Reference No: **2026/NM/92212/W**

Site Address: 477, New Hey Road, Salendine Nook, Huddersfield,  
HD3 3XG

Description: Non material amendment to previous permission  
2022/93868 for erection of single storey rear  
extension, rear dormer, formation of raised deck area,  
external alterations and dropped crossing

#### **DECISION – Non-Material Amendment Approved**

Drawing Title
Proposed floorplan

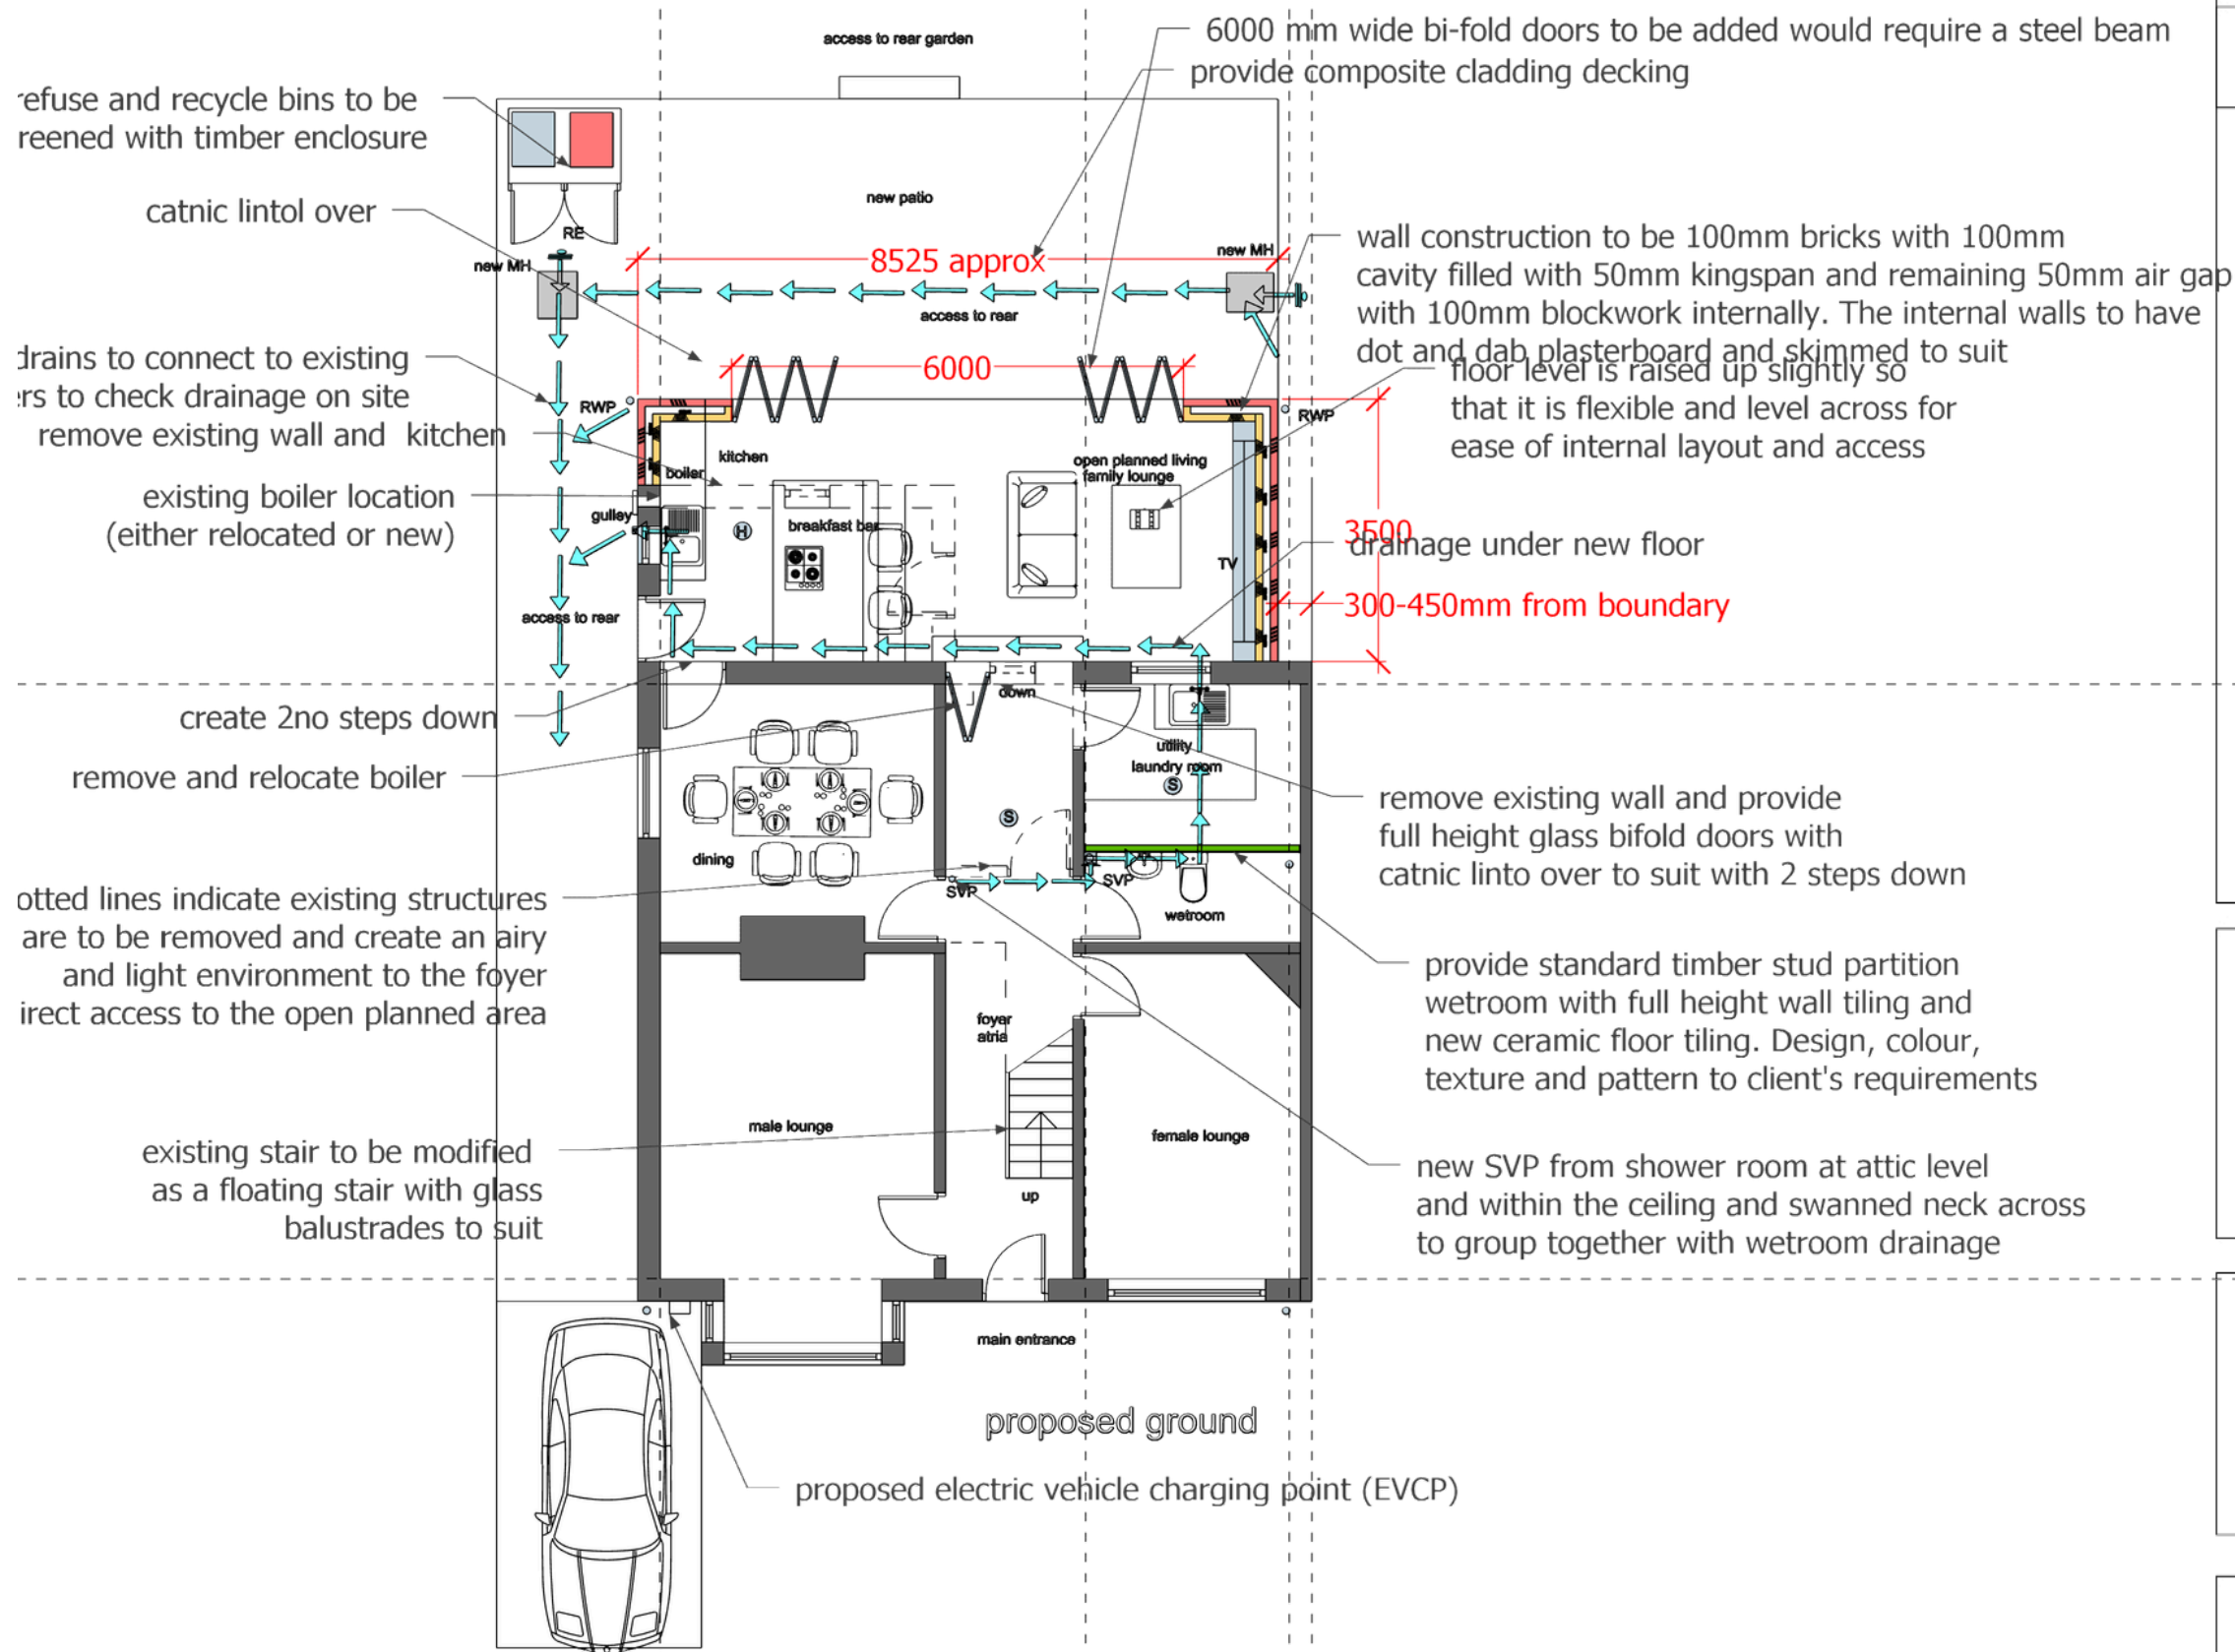
- Converting the existing pitched roof on the rear extension to a flat roof and installing a roof light.
- Replacing the two bi-fold doors in the rear elevation with a single 6-meter bi-fold door.

The amendments sought for converting the existing pitched roof on the rear extension to a flat roof and installing a roof light and replacing the two bi-fold doors in the rear elevation with a single 6-meter bi-fold door as shown on drawings number 106, 105 and 104 are considered acceptable as a non material amendment to the approved scheme under planning reference number 2022/93868.

Drawing Title  
Proposed elevations (minor amendment)

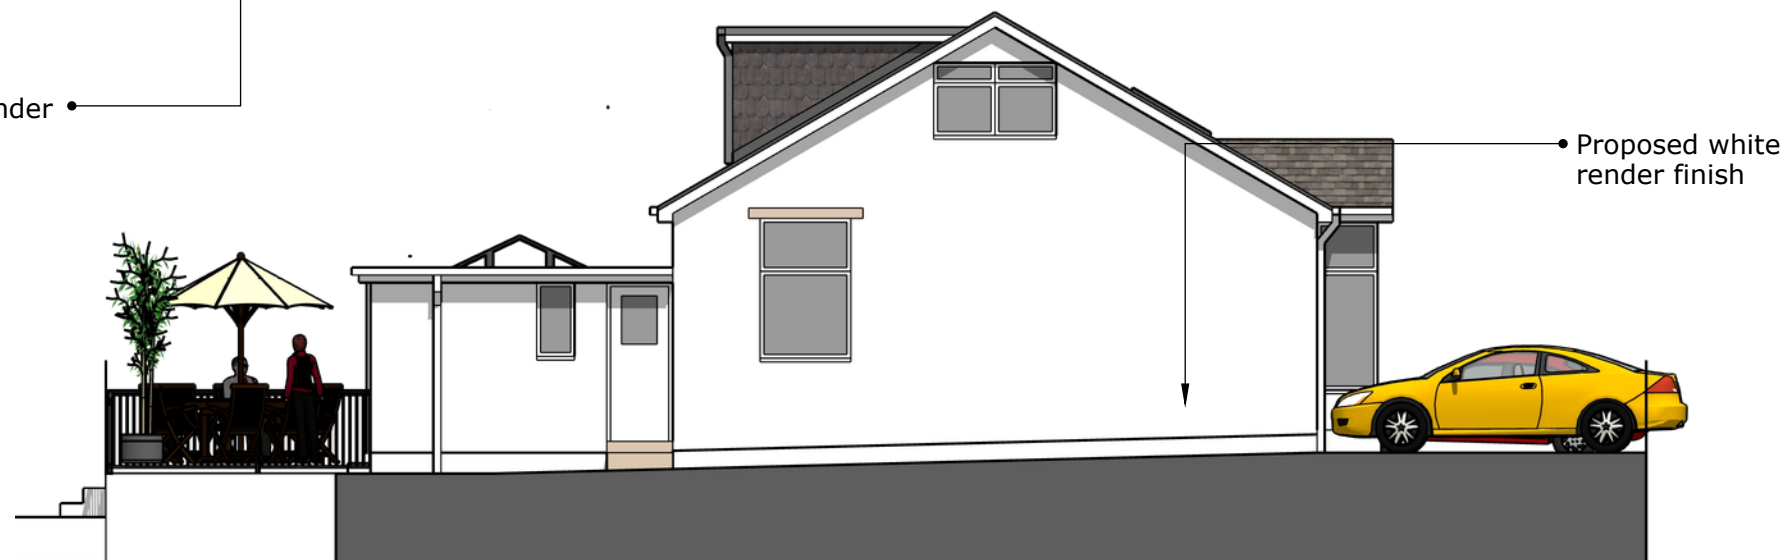
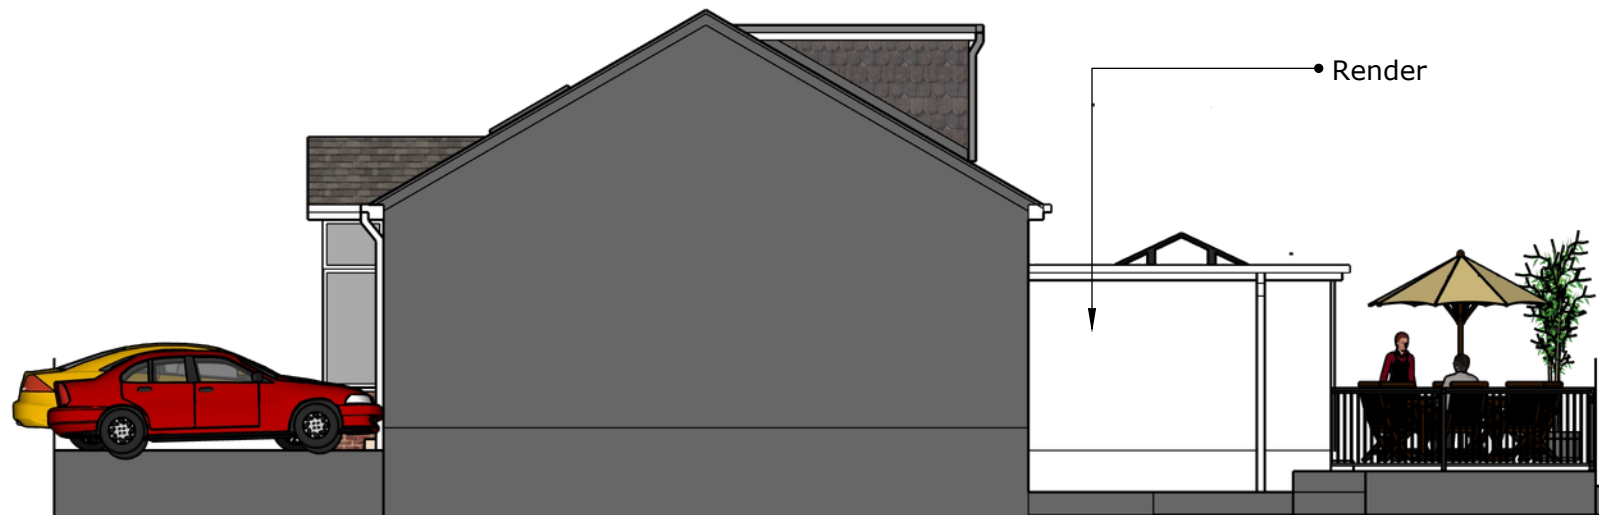
Changes proposed to the roof of the rear extension and the inclusion of an extra sliding door panel to the rear elevation are not considered to be significantly visually different to the existing permission and would therefore not detrimentally impact the property visually. Furthermore, the proposed openings, including the rear sliding door panel and rooflights, will be located no closer to neighbouring properties than existing openings and the scale of the flat roof is lesser than the pitched roof, therefore, there will be no significant impact upon living conditions.
